MEMORANDUM

SUBJECT: SF-18-008 – Lorson Ranch East Filing No. 1
Response to Comments - First Submittal

Final Plat

LORSON RANCH EAST FILING NO. 1

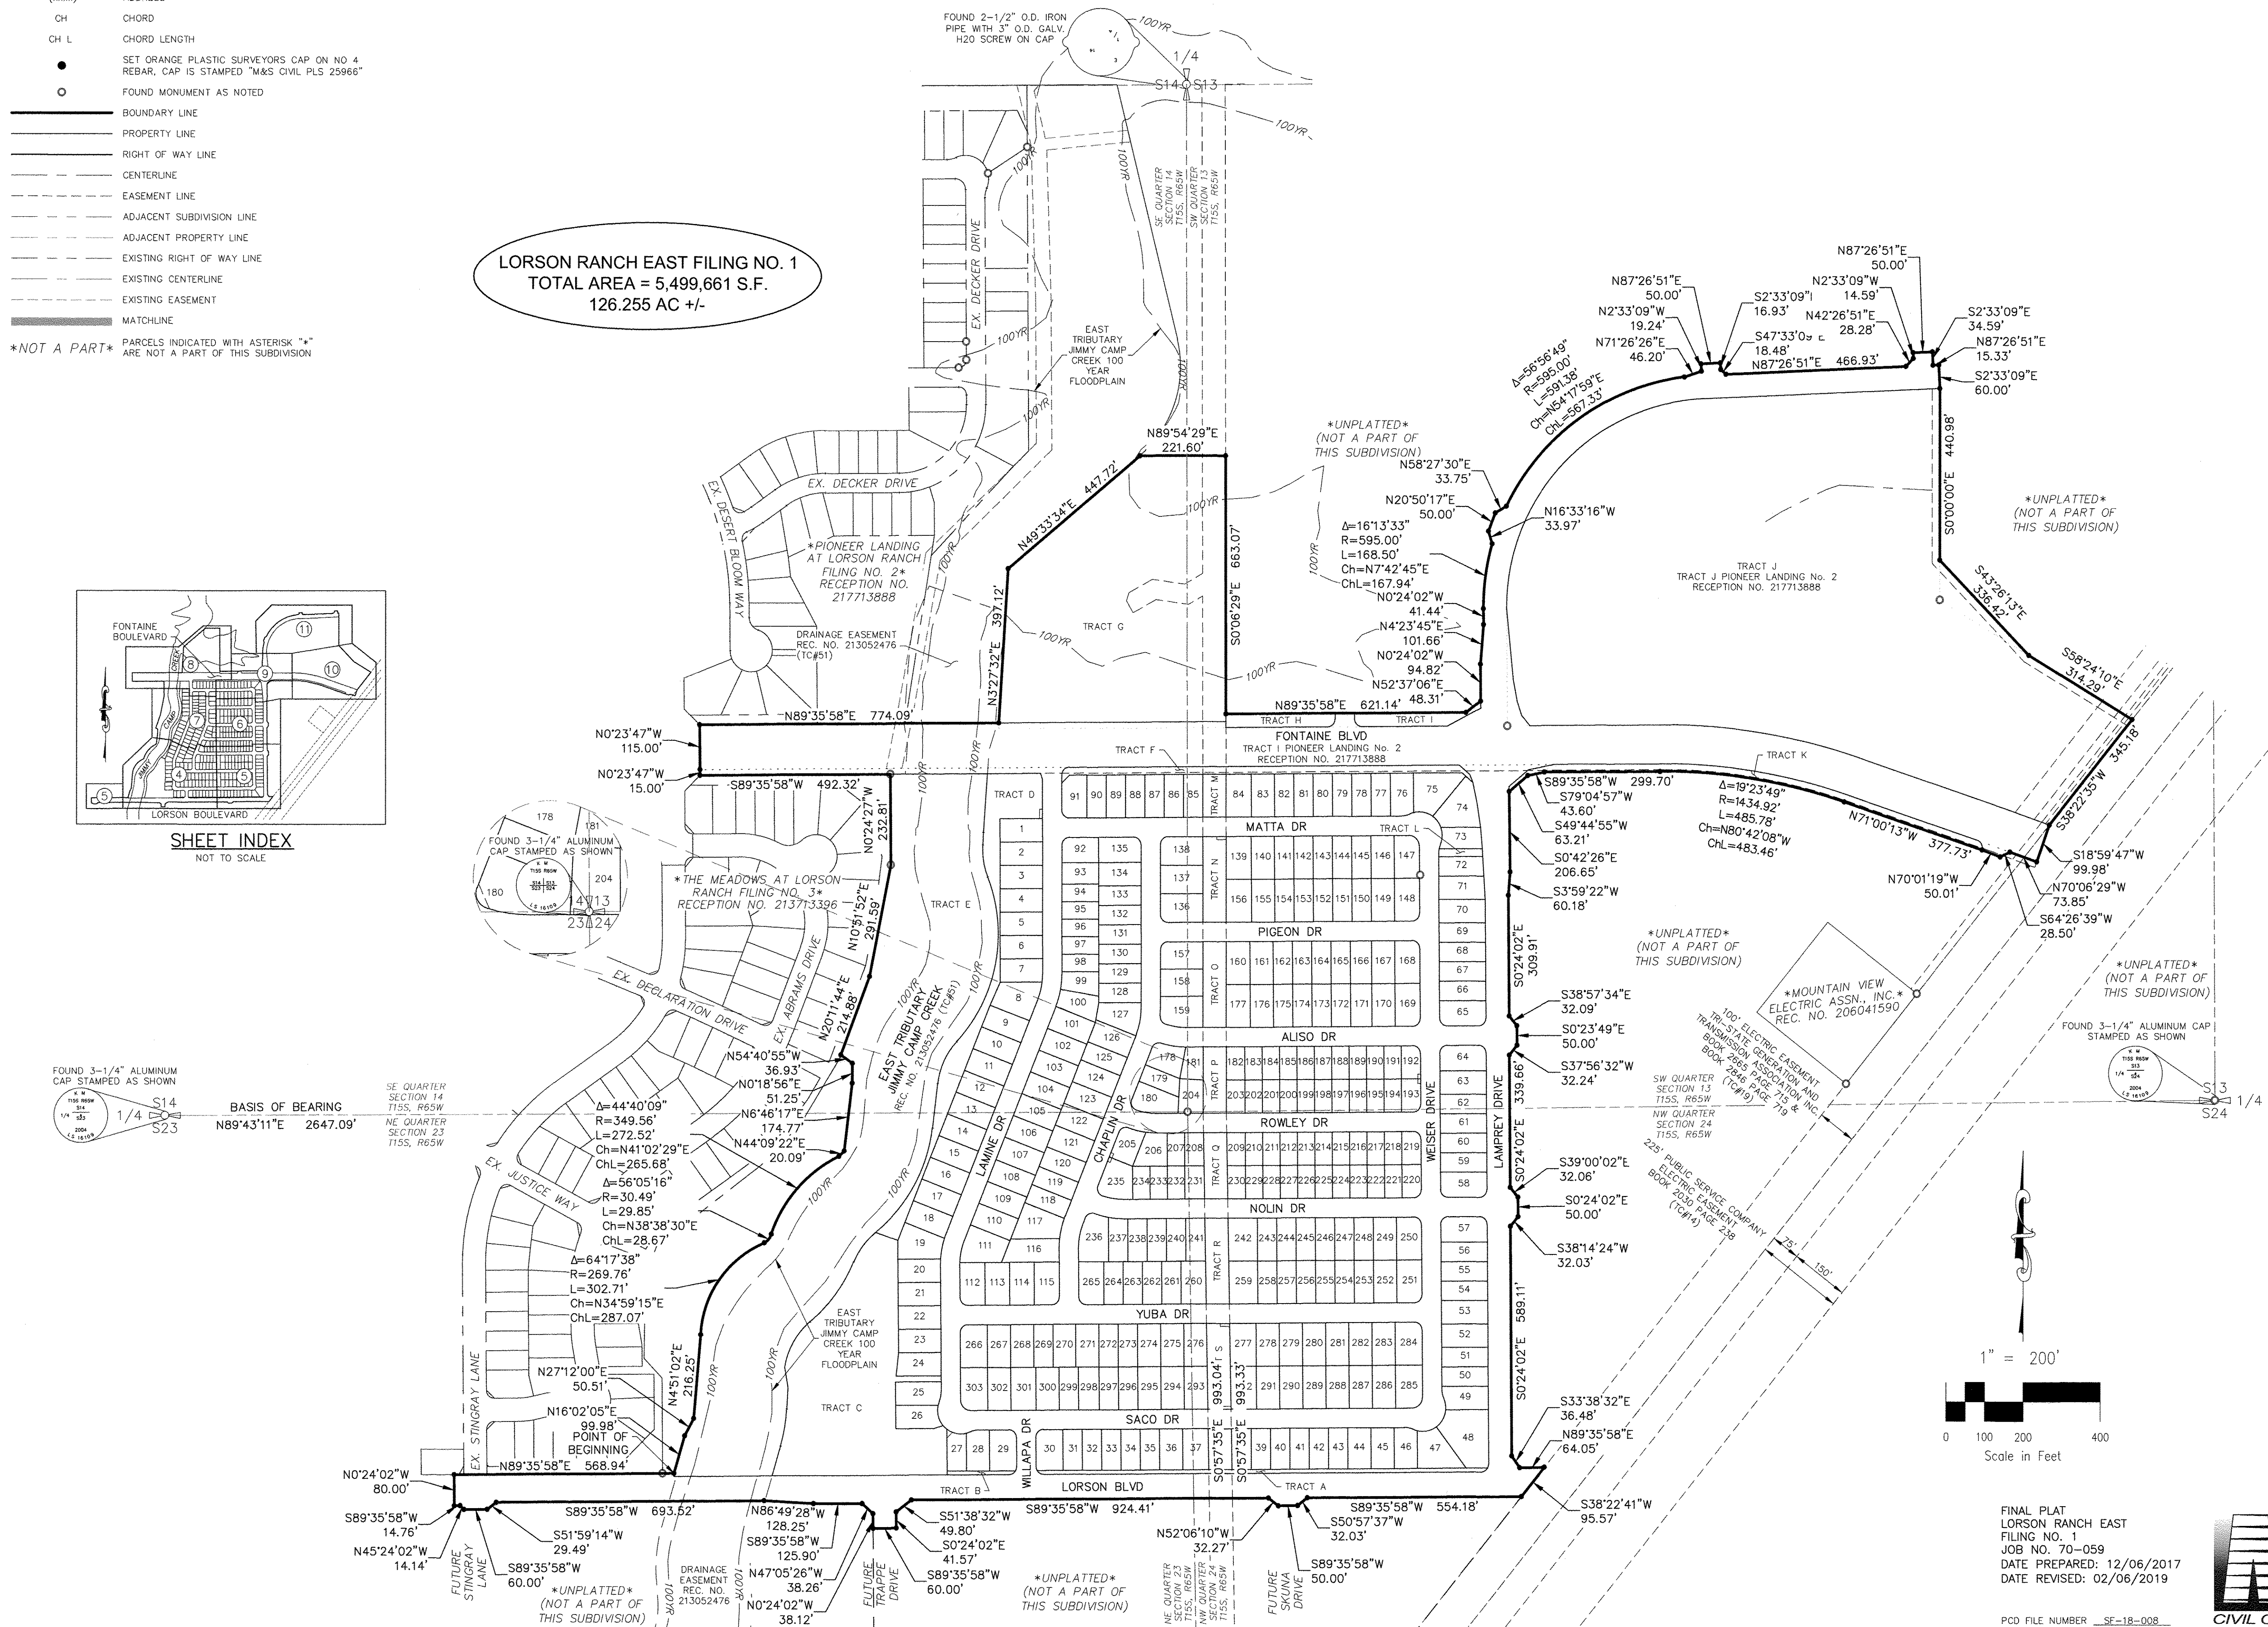
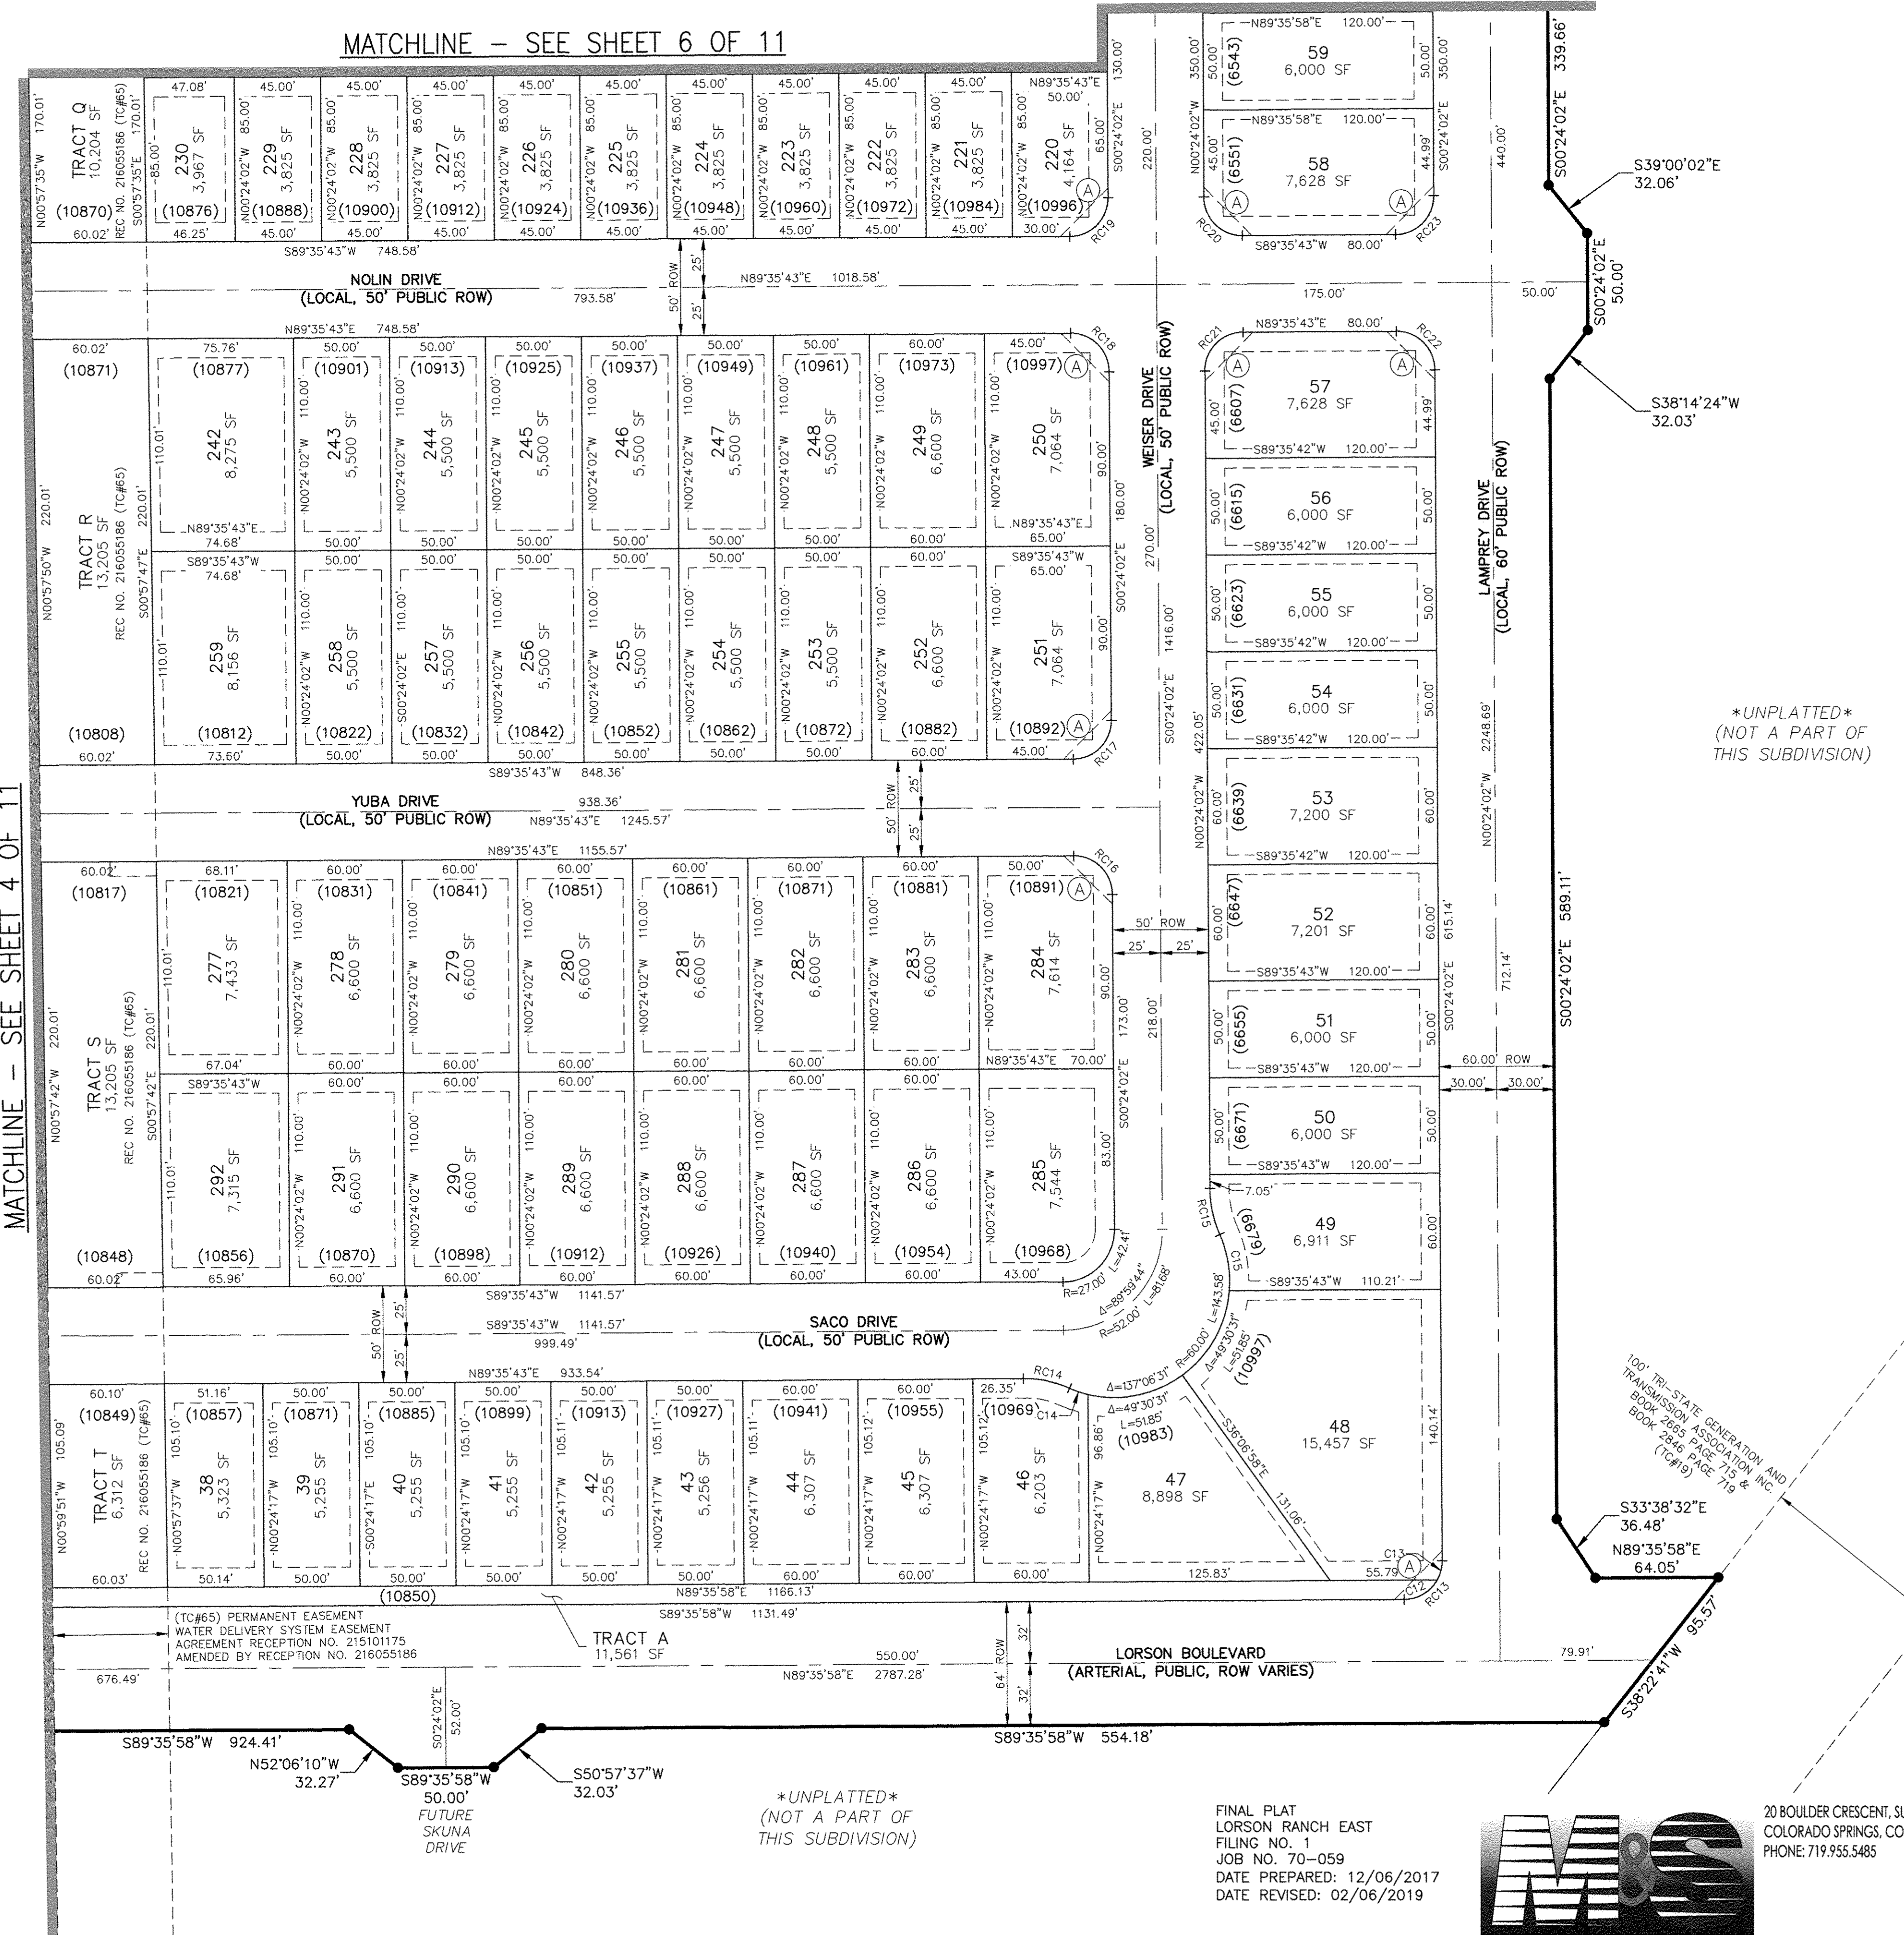
1. Provide documentation of separate easements and vacation/termination documents removing encumbrances on proposed rights-of-way, when available.
2. A segment of the Jimmy Camp Creek East Tributary north of Fontaine Blvd. needs to be included in this plat, with perpetual maintenance of the channel by the Lorson Ranch Metro District, since it serves the detention basin outfall.

5. Amend Note 19 to include Reception # 216055186.
6. Show and label the Permanent Easements granted under Reception Number 216055186
